City of Portland, Maine - Building or Use Permit

Permit No: 2013-01389	Date Applied For: 07/03/2013	CBL: 351 B009001
---------------------------------	--	----------------------------

Proposed Use: Same: Single Family	Proposed Project Description: Remove portion of (existing) deck. Add one concrete filled tube; 8"
---	---

PLOT PLAN

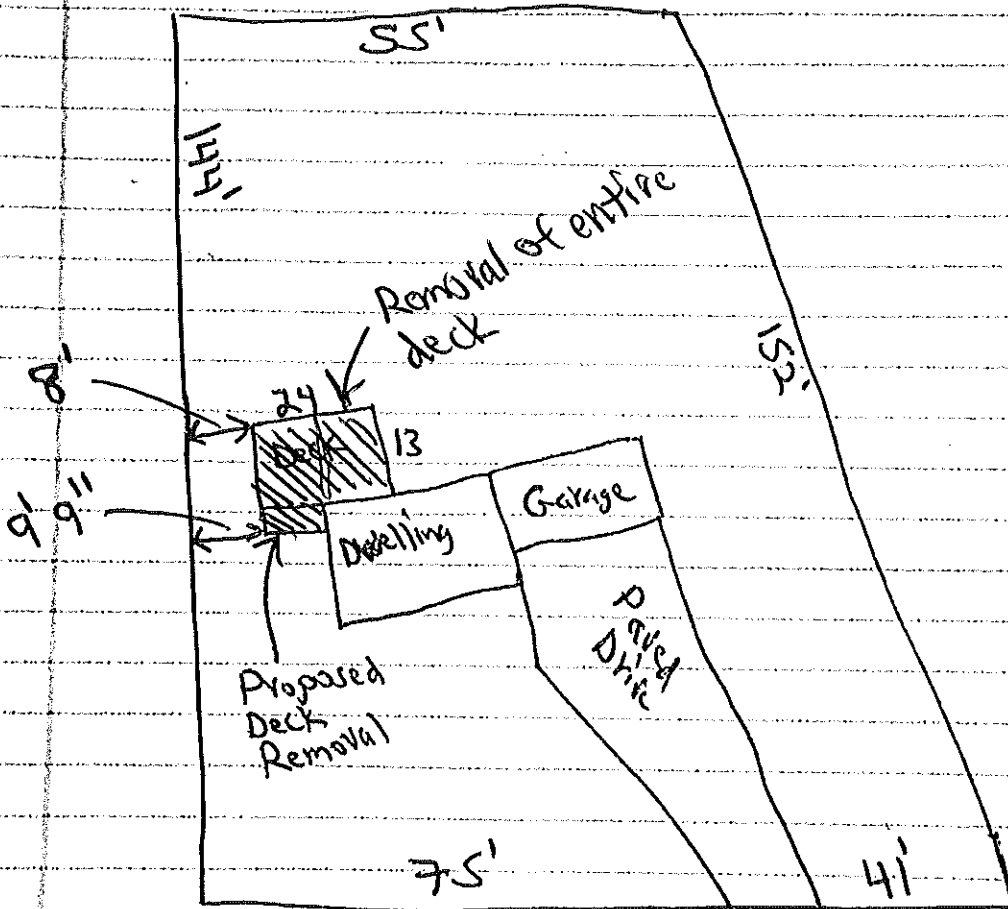
- PLEASE NOTE: That the partial deck removal is being approved. However, research of our files indicates that the construction of the original deck was never properly permitted. The deck is illegal and DOES NOT meet the current R-2 Zone setbacks. The deck shall either be removed or made to be conforming under a separate permit application.
